Re: Planning Application 20/0696

Address: 36 Durham Road Wilpshire BB1 9NH

**Description: Partial demolition of existing garage and extension to garage.
Construction of single storey rear extension**

## Proposed Site Plan

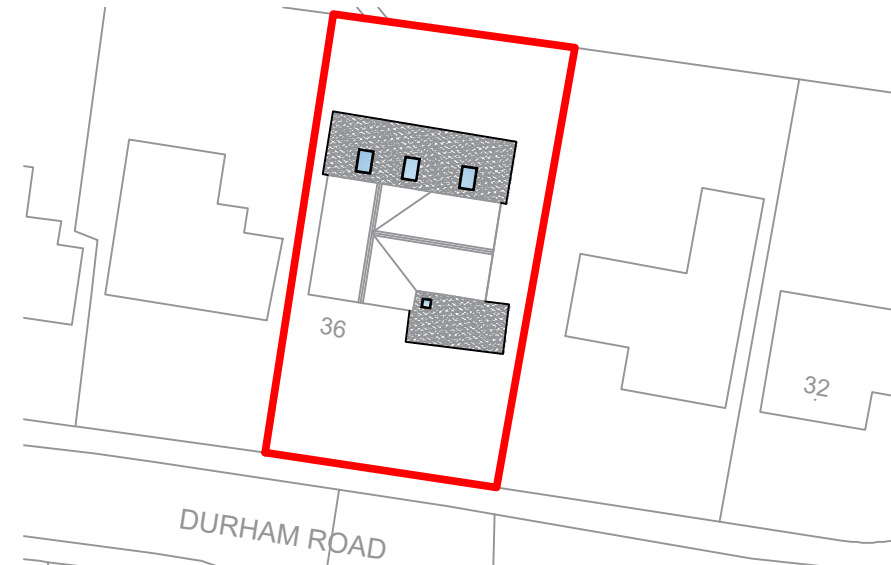
With respect to this application whilst we would not wish to raise an objection to the principle of the development, there are concerns regarding the provision of off street parking.

In order to allay our concerns we would look for plans showing how 3 off street parking spaces can be achieved.

Guidance regarding the size of car parking spaces garages can be found in the Department for Transports document Manual for Streets. Generally a garage is considered to be acceptable at 3m x 6m and a car parking space is 2.4m x 4.8m. Where a space is in front of a garage this should be lengthened by at least 0.5m to allow for a garage door to open with damaging a vehicle parked in front of it. Additionally, where the driveway is also the pedestrian access to the dwelling an additional 0.8m should be provided for pedestrians, an extra 0.6m is also expected where the space is adjacent to fence wall or other obstruction that would hinder the door opening to allow free access.
